From: Anthony.Collier@hertfordshire.gov.uk
Sent: 12 April 2017 10:51
To: Planning
Subject: Planning application 6/2017/0226/HOUSE - 311 St Albans Road

District ref: 6/2017/0226/HOUSE

311 St Albans Road
Hatfield
AL10 9RJ

Erection of wall and gates to front garden

plan - proposed

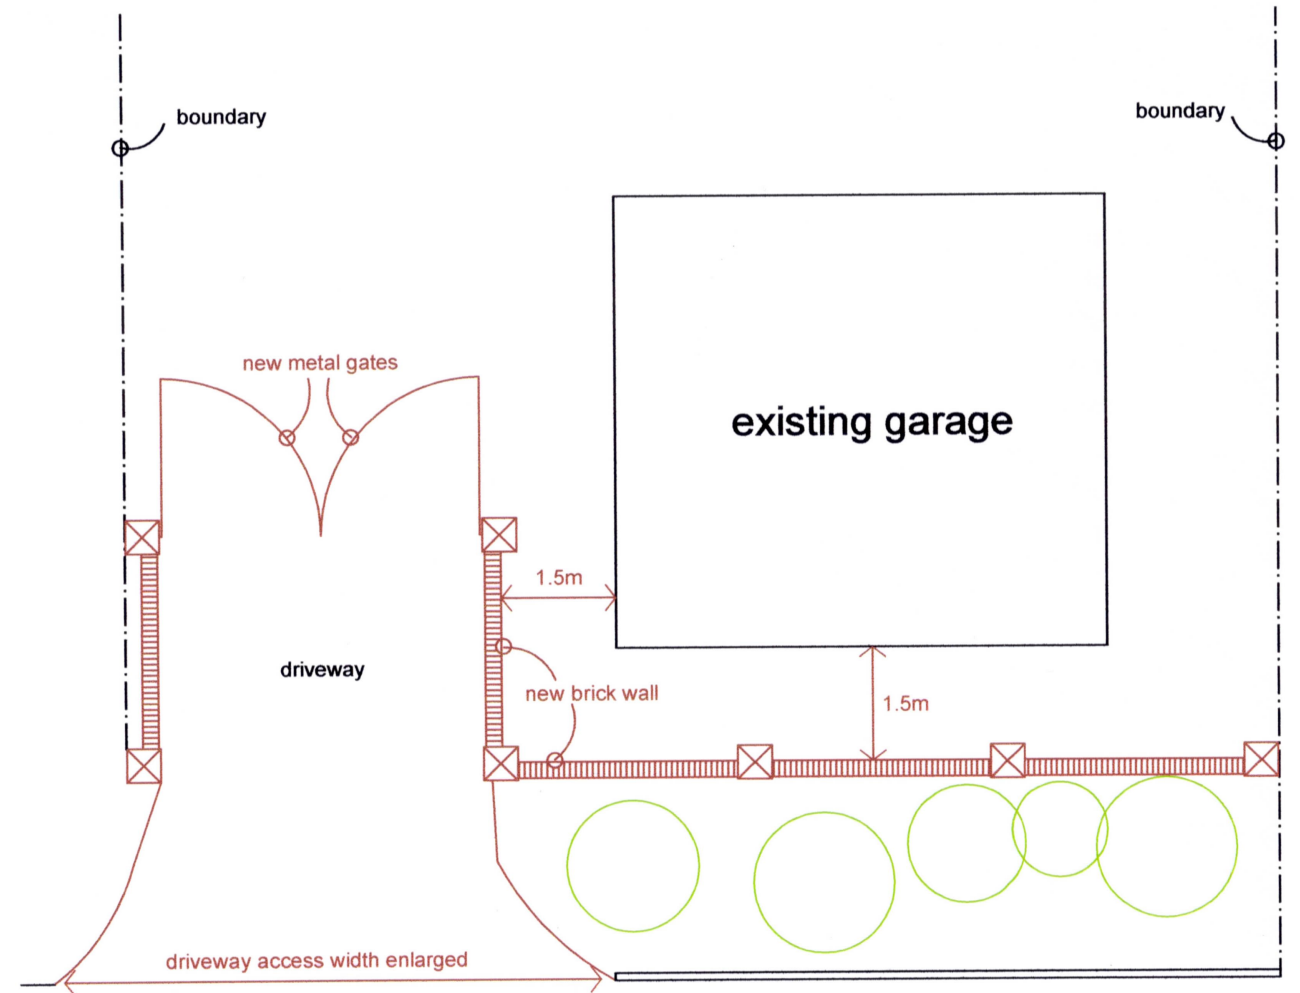
Whilst the application form states that works will be required within the public highway, it is not made clear if the widening works will be within the public highway or within private land. Should works be required

within the highway the widths will be contained to the districts vehicle cross over dimensions policy of 5.4 meter of dropped kerb.

The design is unlikely to impact on visibility for highway users or for access/egress of the dwelling.

the location of the gates is such that it is unlikely any waiting on the public highway will occur.

SHC 02: Prior to the commencement of the development hereby permitted full details (in the form of scaled plans and / or written specifications) shall be submitted to and approved in writing by the Local Planning Authority in consultation with the Highway Authority to illustrate the following: -

1) Access arrangements. 2) Proposed Widths of dropped kerb
